Morgan and Morecambe Offshore Wind Farm: Transmission Assets

Appendix G3 to Natural England's Deadline 3 Submission
Natural England's further advice on Onshore Ecology and Nature Conservation

Planning Inspectorate Reference EN020028

07 July 2025

**Figure 1.4: Provisional ALC mapping within the study area (sheet 1)**

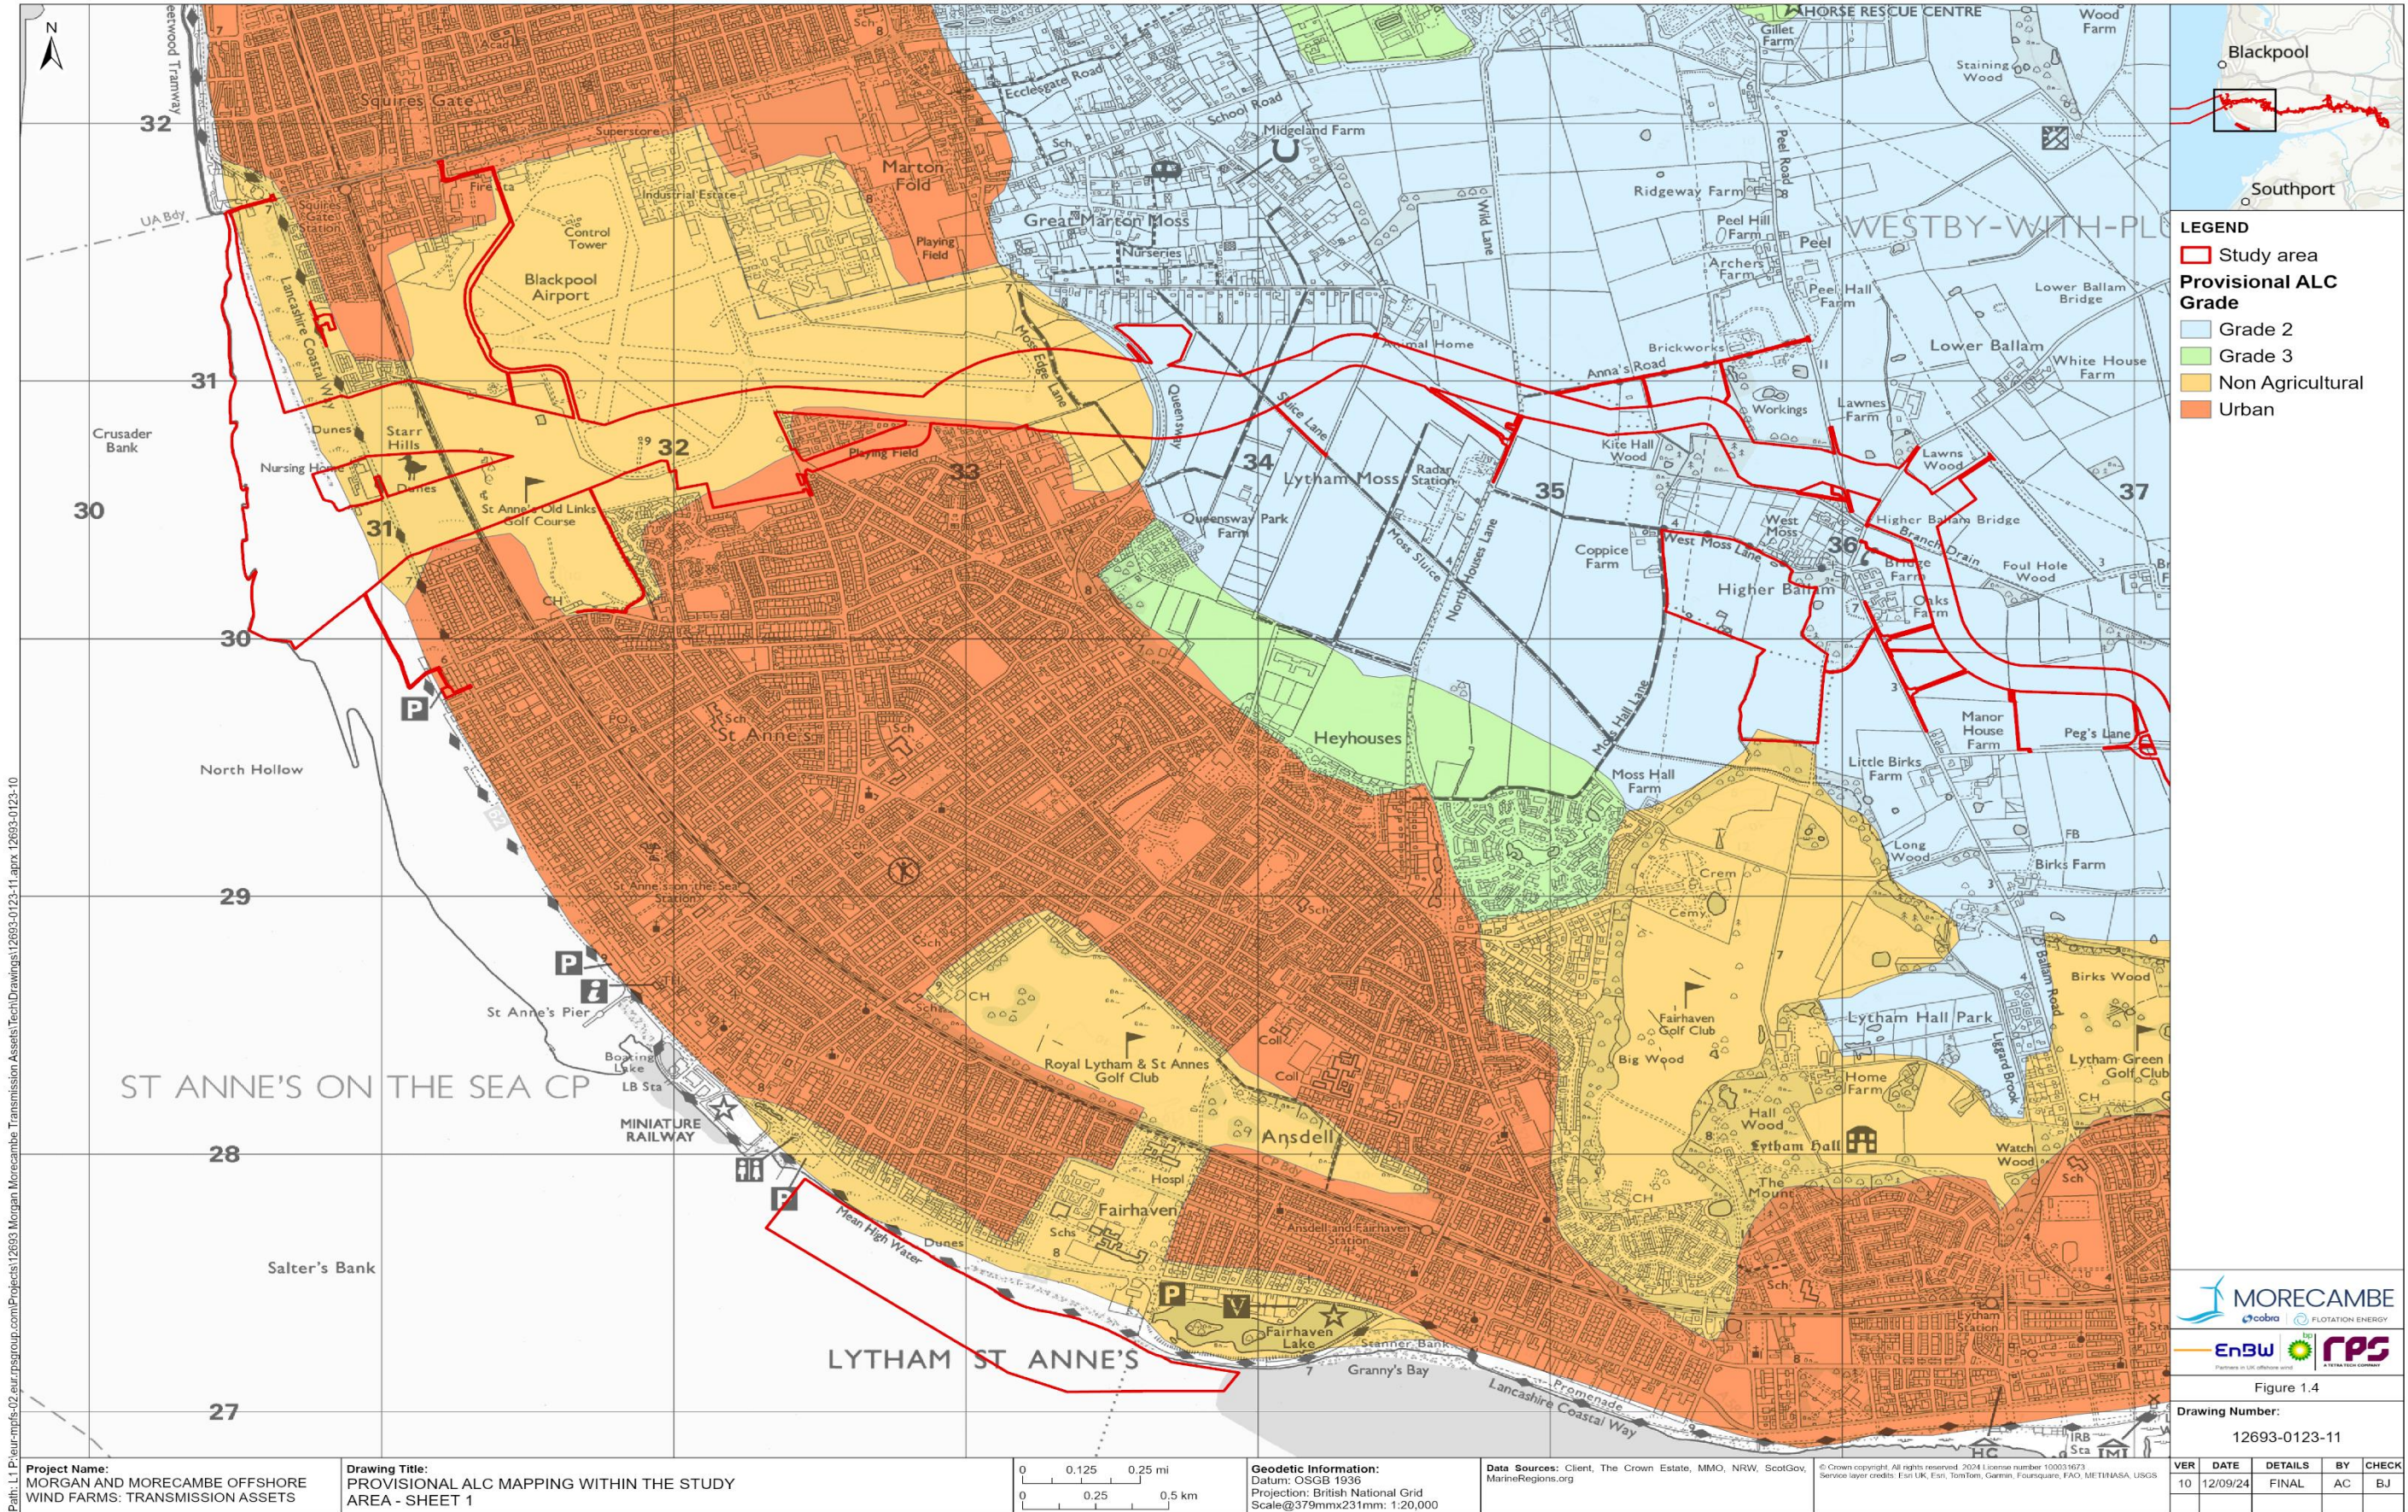
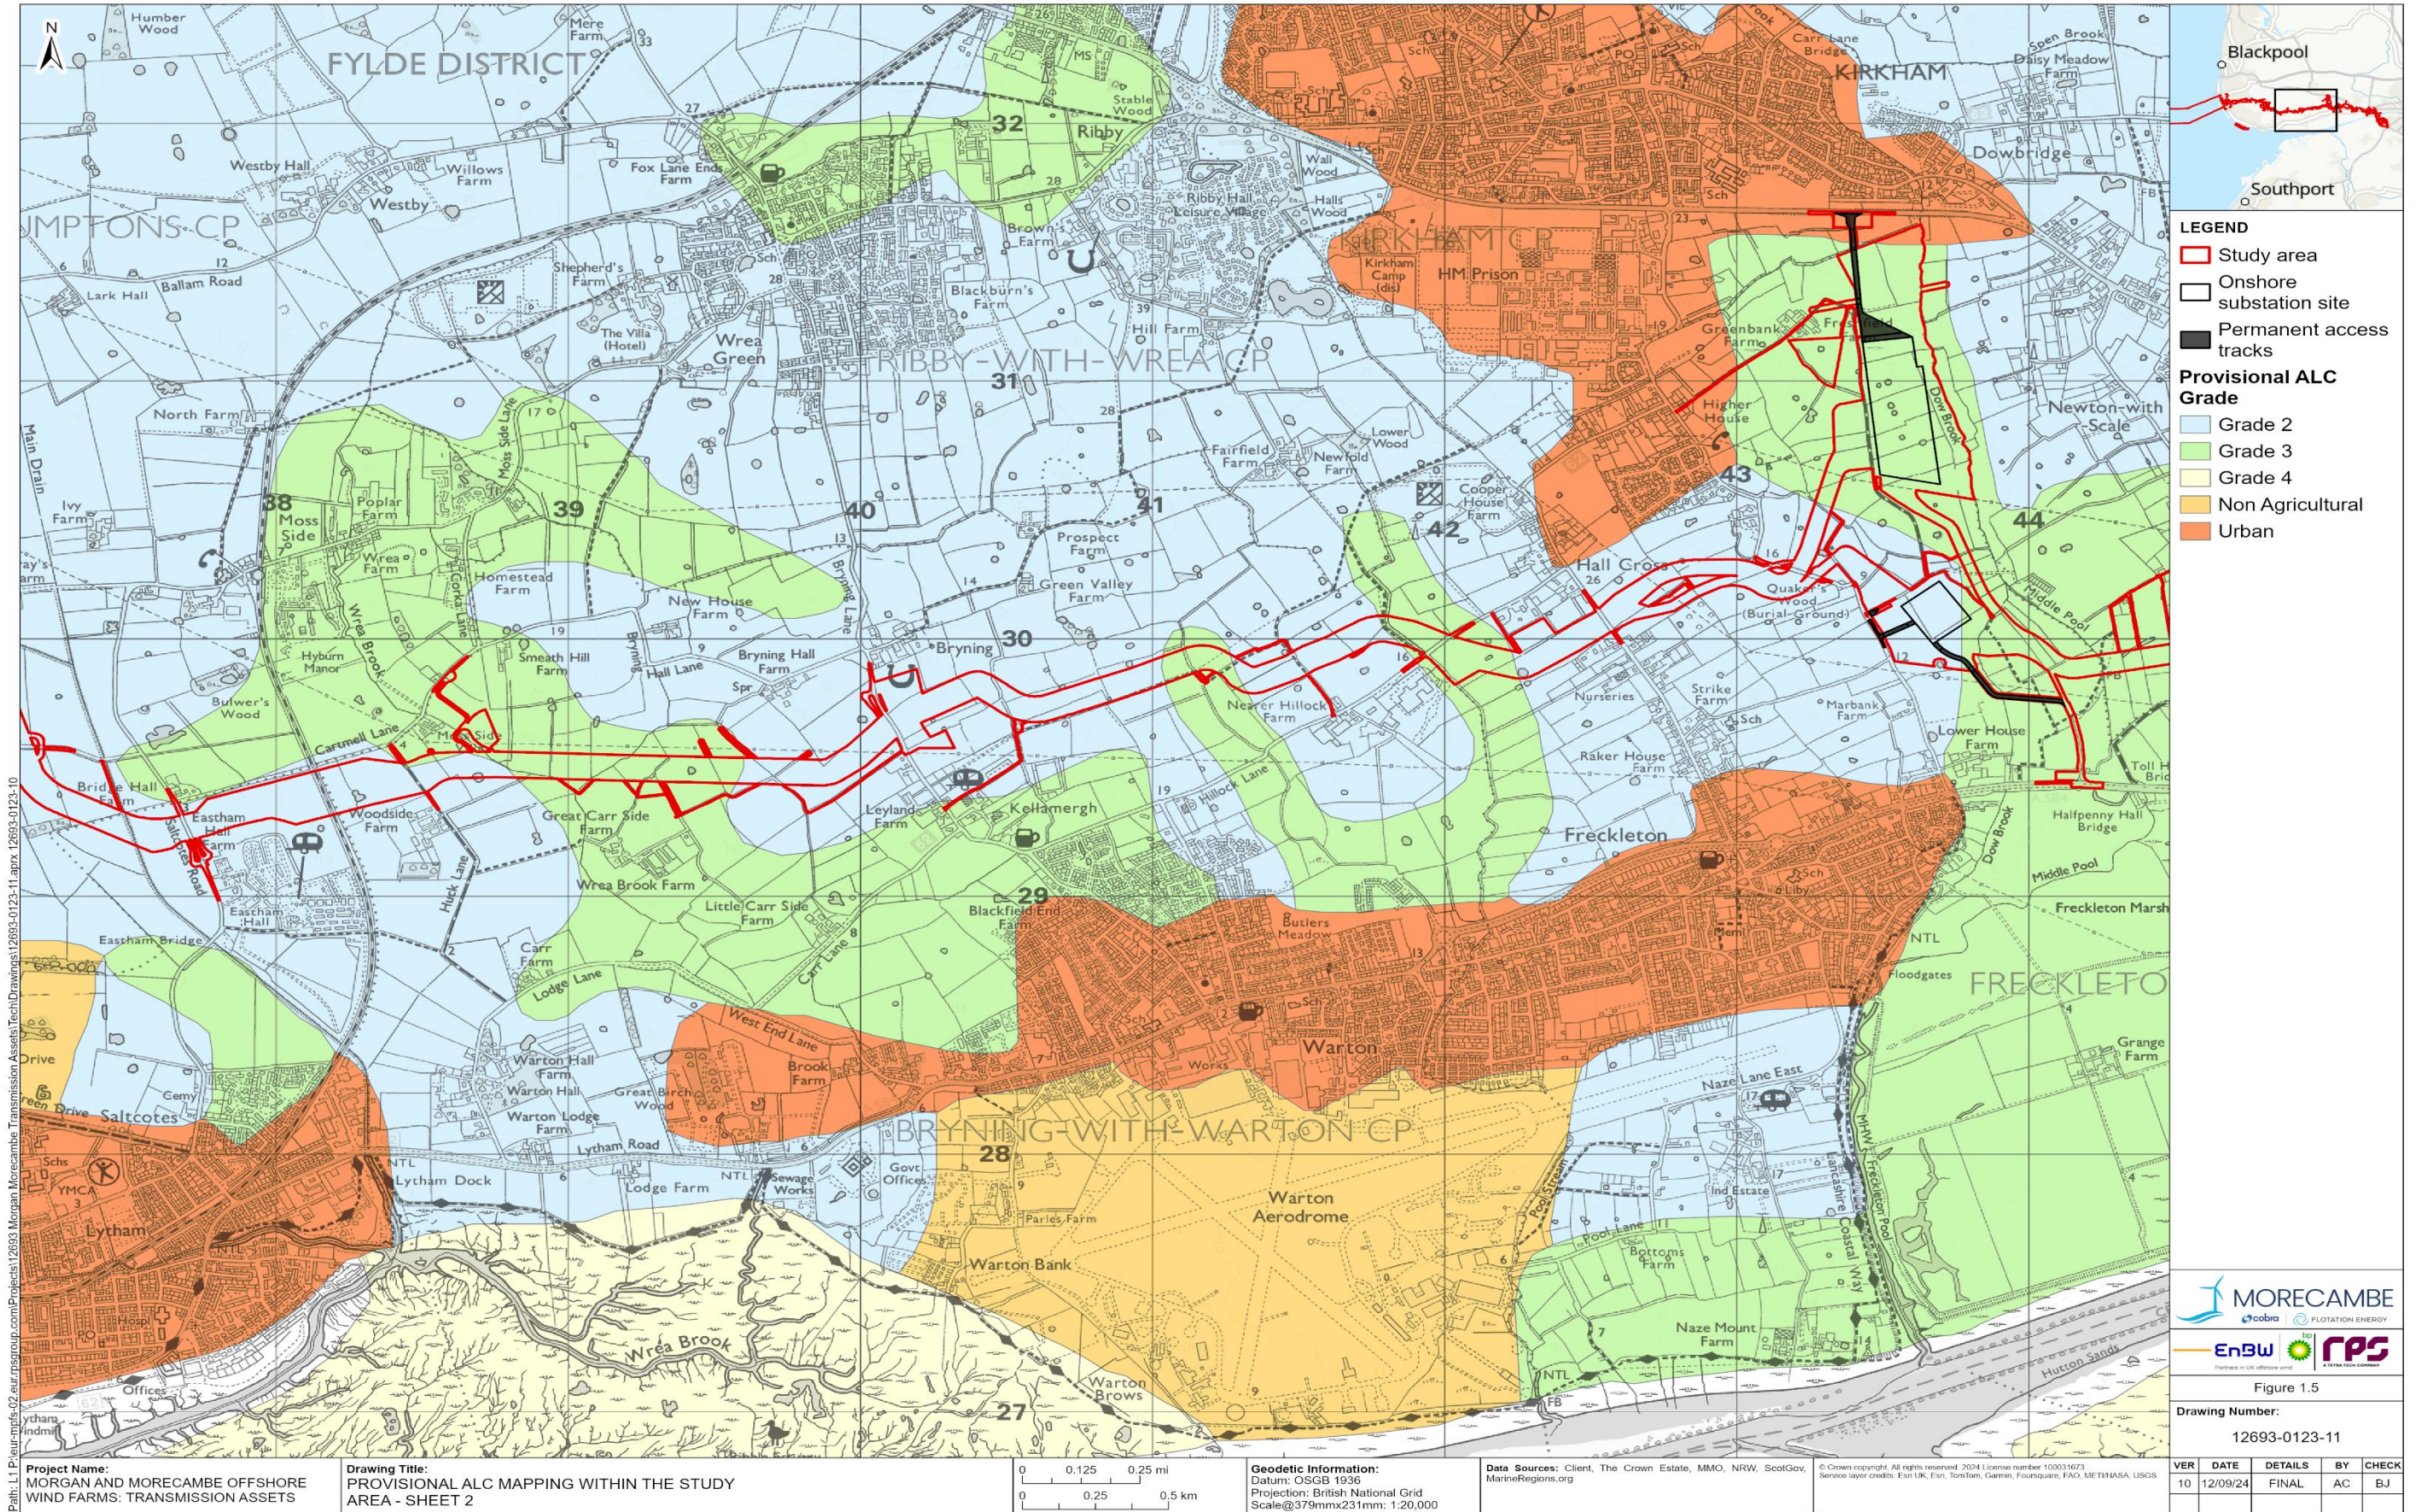
In the absence of a detailed, site-specific soil and Agricultural Land Classification (ALC) survey and assuming that all mapped ALC Grade 3 land are Best and Most Versatile (BMV) soils (i.e. Subgrade 3a), it is not possible to provide an accurate baseline and demonstrate the likely potential impacts. So, whilst any mitigation may be regarded as precautionary, it means that the Applicant is unable to show how it avoids impacts to BMV soils nor the design of potential mitigation to safeguard the soil resources.

The Environmental Statement (ES) should quantify the areas of land according to Grades 1 to 5 of the ALC, including differentiating between Grades 3a and 3b. While Natural England recognises the Applicant's acknowledgement of the deficiencies within the provisional dataset and that provisional mapping provides an indication of the ALC grade, and thus the potential impact on BMV agricultural land; it does not provide the soil details required to inform soil management which would feed into the Soil Management Plan. There is a risk of soil damage, ALC degradation and long term or permanent loss of BMV soils from cable installation. Soil will need to be handled according to best practice and reinstated to a high standard to reduce the impacts. The results from a detailed ALC survey would provide soils data to inform a soil management plan for the whole site regardless of whether the use is permanent or temporary in nature and provide the Secretary of State with the necessary comfort in the mitigation measures.

Natural England acknowledges the Applicant's effort to provide a conservative, worst-case assessment of agricultural land quality by applying the highest ALC grade within mixed soil types. However, in line with Paragraph 5.11.34 of the Overarching National Policy Statement for Energy (EN-1), it is essential that development proposals demonstrate how the use of Best and Most Versatile (BMV) land, Grades 1, 2, and 3a, has been avoided where possible, and that any unavoidable impacts are clearly justified and appropriately mitigated.

While the Applicant has presented ALC data and committed to further surveys prior to construction, Natural England remains concerned that the current assessment may not fully demonstrate how impacts to BMV land has been minimised across all elements of the

Transmission Assets. The reliance on a worst-case assumption, while precautionary, does not substitute for a spatially explicit breakdown of BMV land take by infrastructure component, nor does it confirm whether alternative routing or siting options were considered to reduce BMV land losses.

- Clearly demonstrate how the layout has sought to avoid BMV land;
- Provide a transparent breakdown of BMV land affected by each infrastructure element; and
- Ensures that the forthcoming detailed Soil Management Plan includes enforceable measures to protect and restore BMV soils during and after construction.
